Engineers Comments Regarding Surface Water Drainage

Application No: P/111/21/RES

Site Address: Land adjacent to Sefton School House Sefton Road Bognor Regis PO21 3EE

Description of Works: Approval of reserved matters following P/116/19/OUT for the erection of 2 No detached houses & 4 No semi detached dwellings.
This site is in CIL Zone 5 and is CIL Liable as new dwellings.

Project
Land adjacent to Sefton School House
Sefton Road
Bignor Regis
PO21 3EE
Drawing Title
Block Plan as Proposed

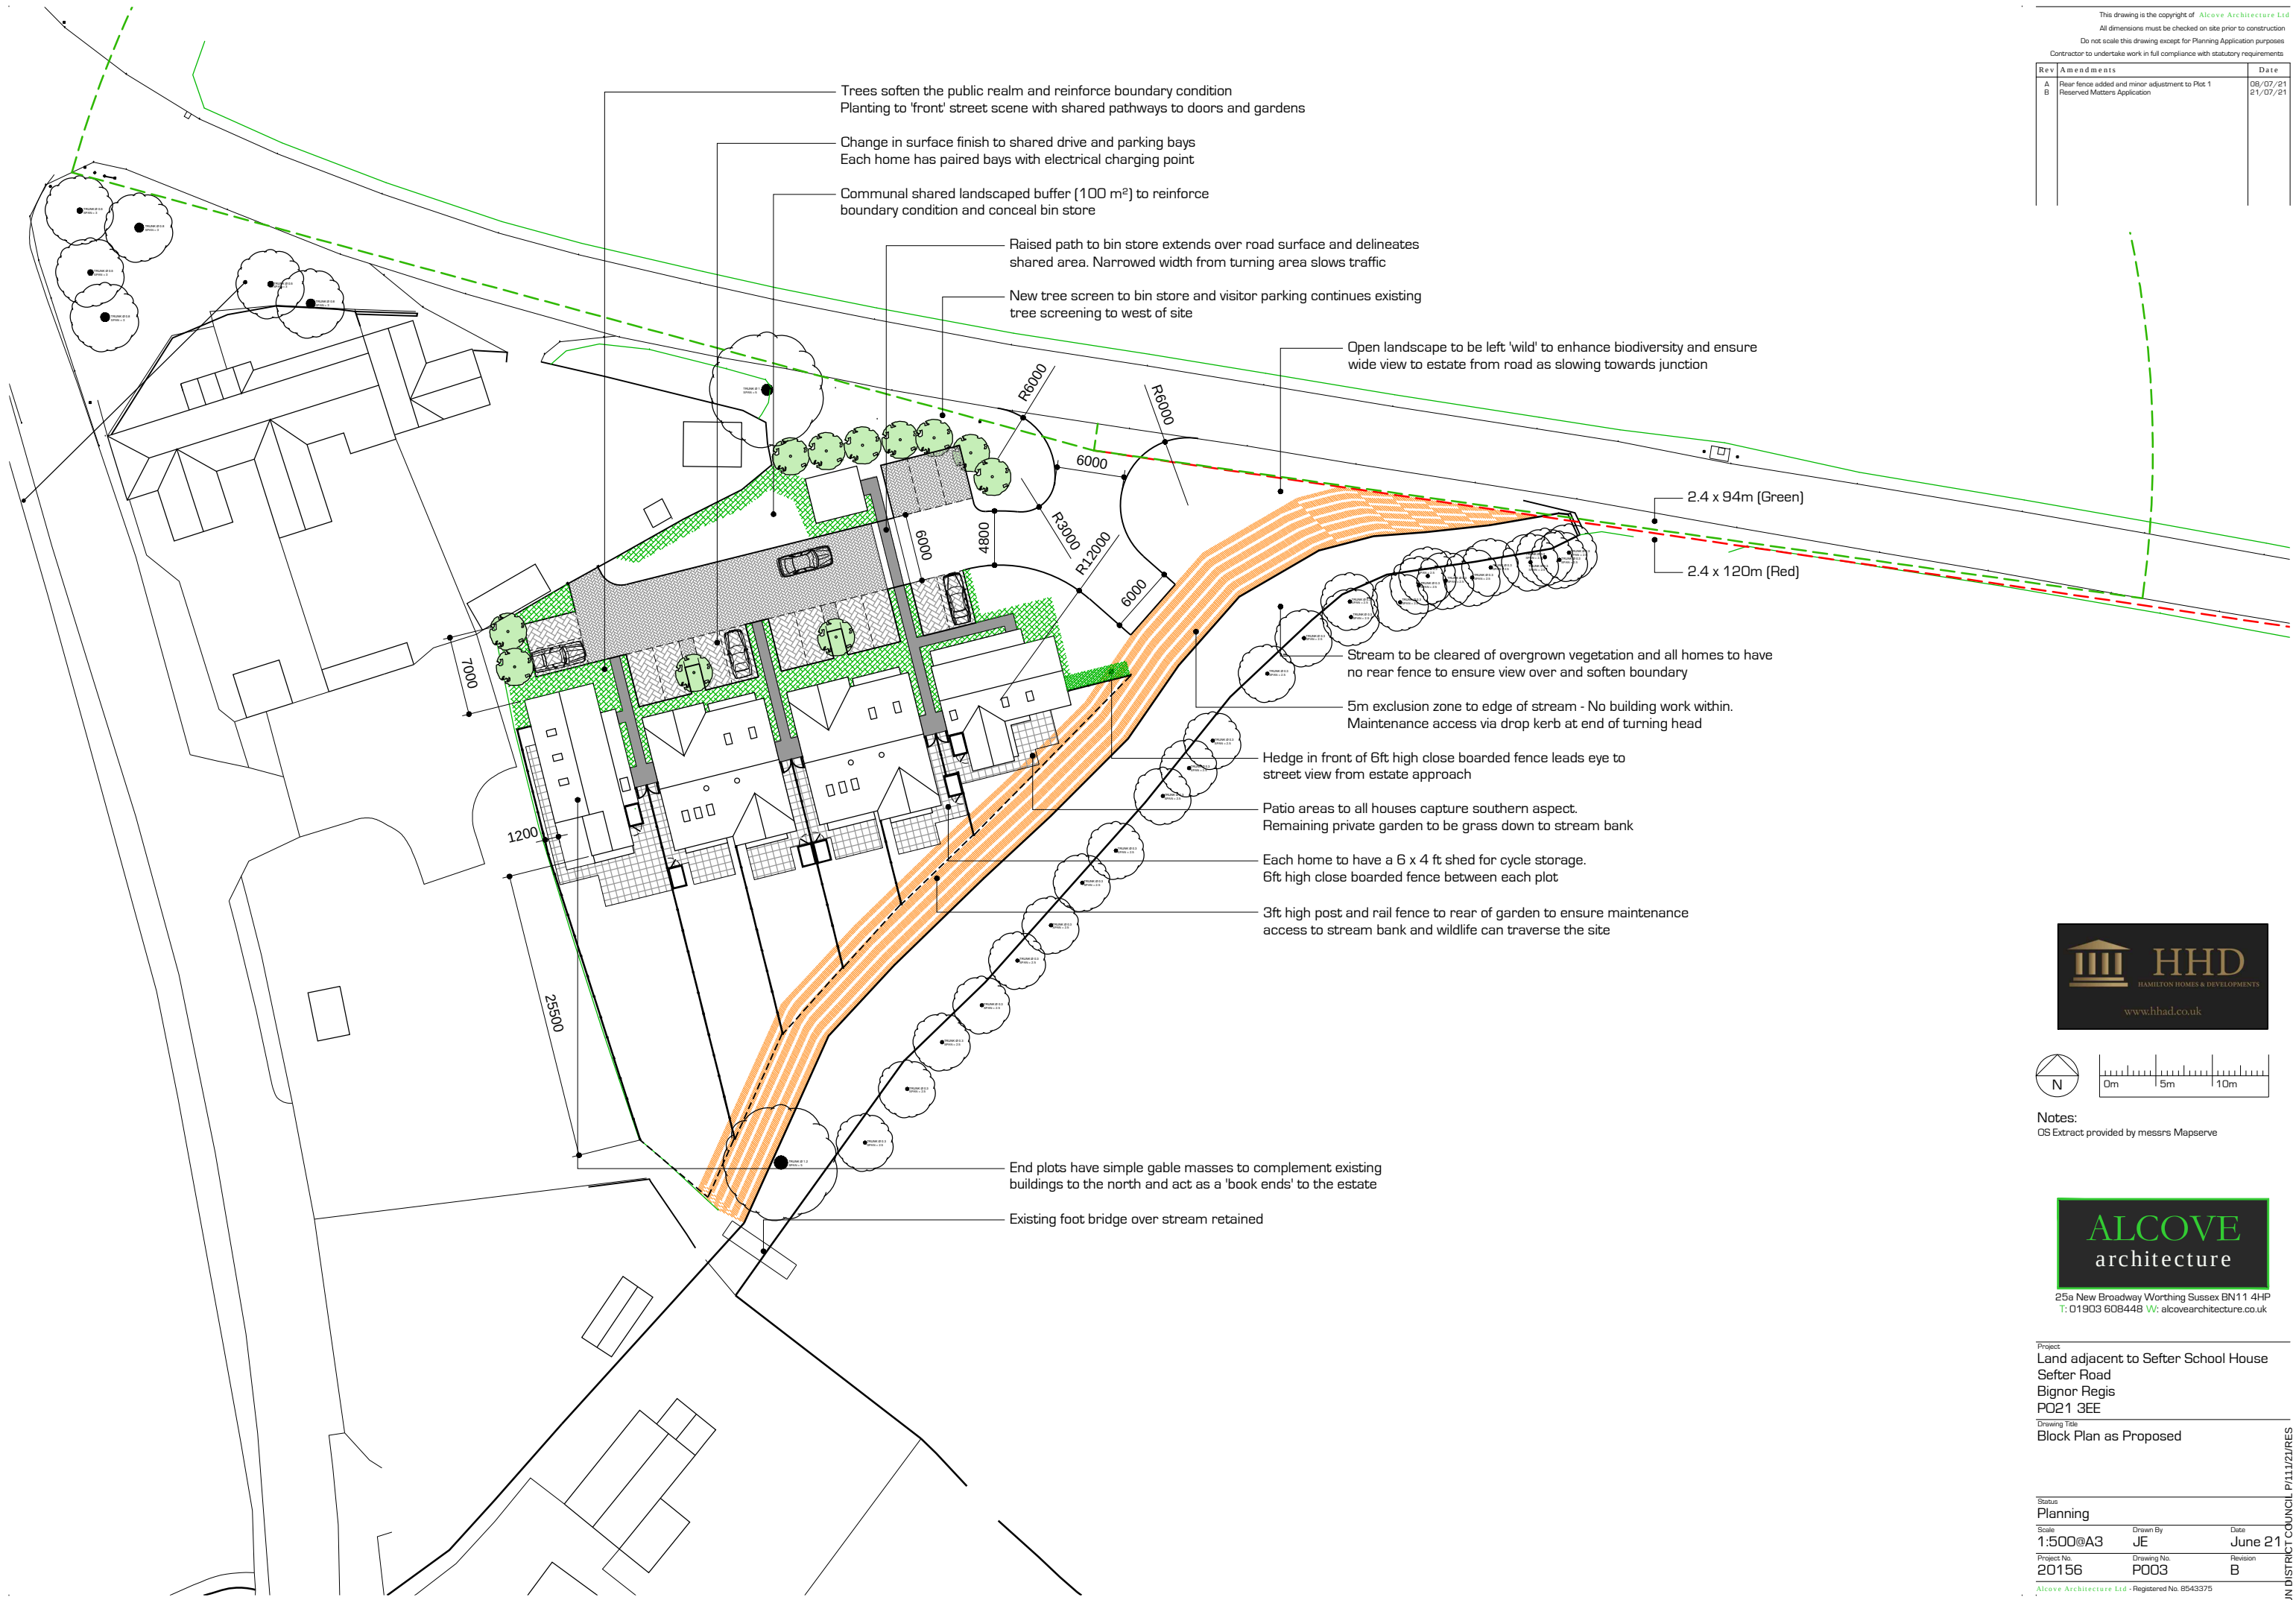
No surface water drainage information has been supplied as part of this reserved matters application. We are pleased to see that the 3m easement has been clearly shown from the watercourse on the southern boundary on the site plans.
